**City of Portland, Maine - Building or Use Permit Application**  
 389 Congress Street, 04101 Tel: (207) 874-8703, Fax: (207) 874-8716

<b>Permit No:</b> 05-0993	<b>Issue Date:</b>	<b>CBL:</b> 013 F002001
------------------------------	--------------------	----------------------------

<b>Past Use:</b> three unit residence	<b>Proposed Use:</b> three unit residence rebuilt to original condition after lightening strike and fire	<b>Permit Fee:</b> \$471.00	<b>Cost of Work:</b> \$50,000.00	<b>CEO District:</b> 1
<b>Proposed Project Description:</b> replace all drywall, interior trim & floors, vinyl windows on 3rd floor; patch roof shingles		<b>FIRE DEPT:</b> <input type="checkbox"/> Approved <input type="checkbox"/> Denied	<b>INSPECTION:</b> Use Group: Type	
		Signature:	Signature:	
<b>PEDESTRIAN ACTIVITIES DISTRICT (P.A.D.)</b>				
Action: <input type="checkbox"/> Approved <input type="checkbox"/> Approved w/Condition <input type="checkbox"/> Denied				
Signature: _____ Date: _____

3rd Floor
 1A/10VH
 7-9 Please S

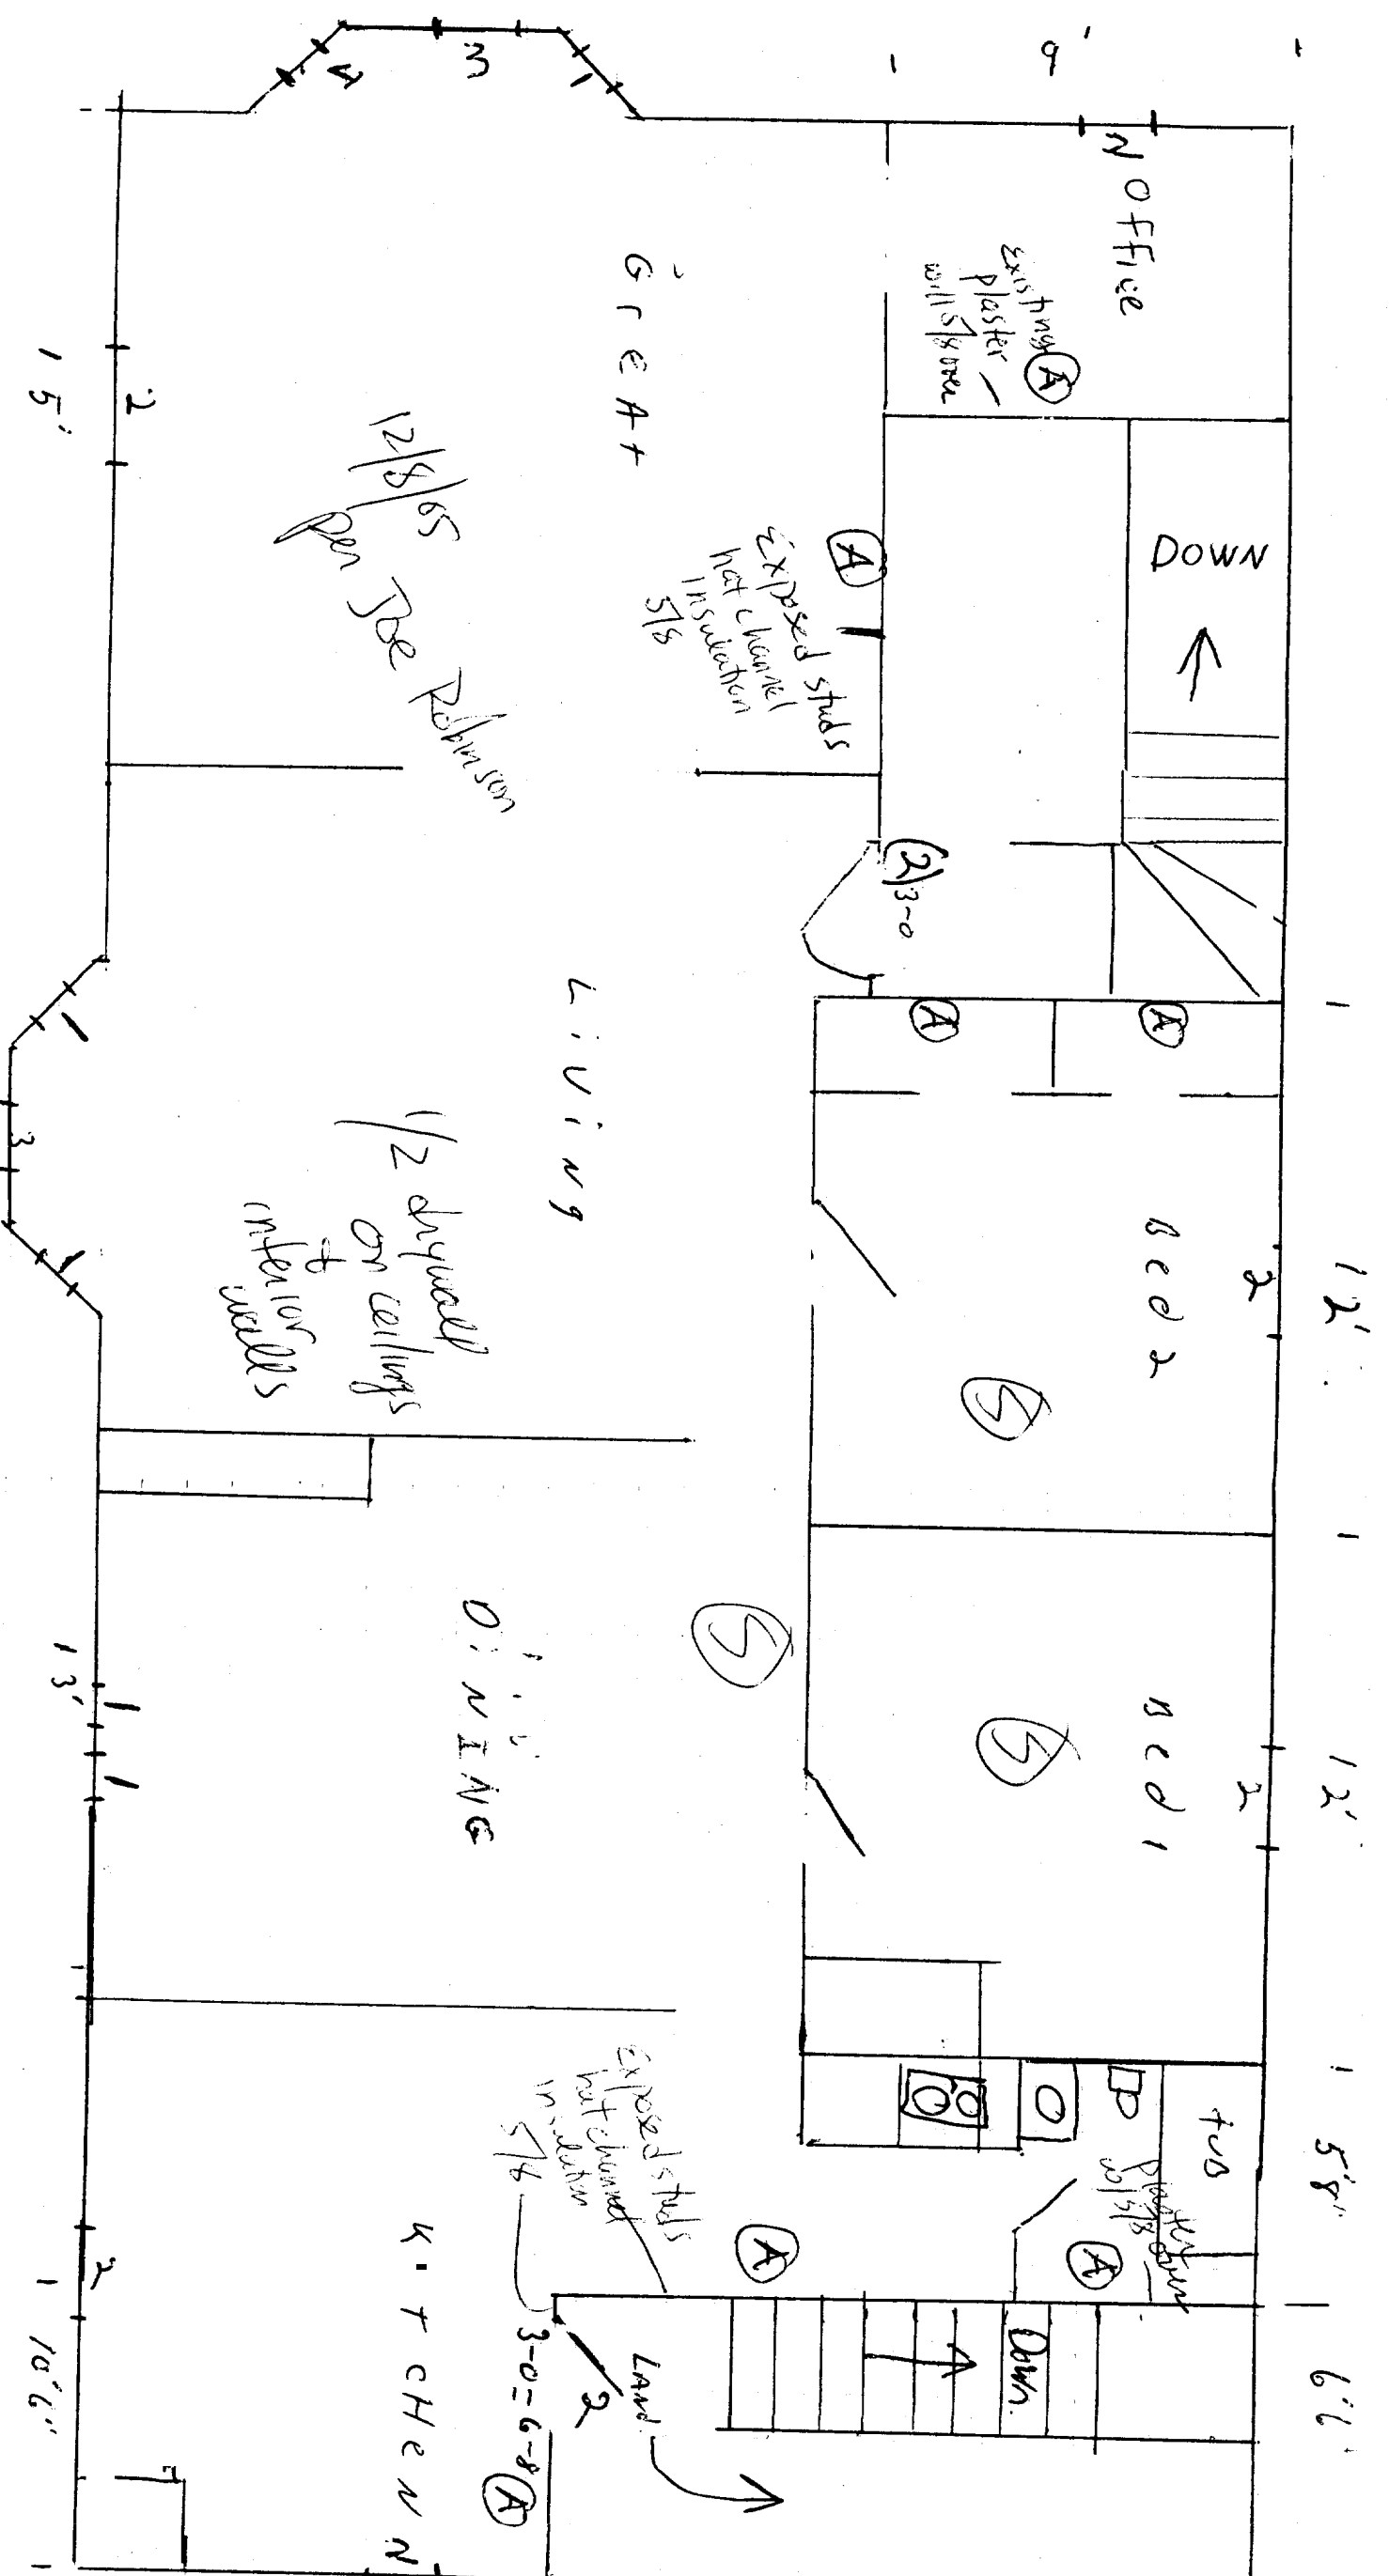
08/11/2005-tmm: left message w/builder - need fire wall and floor/ceiling assembly details. Need to know if there is any framing and what flooring is being removed.
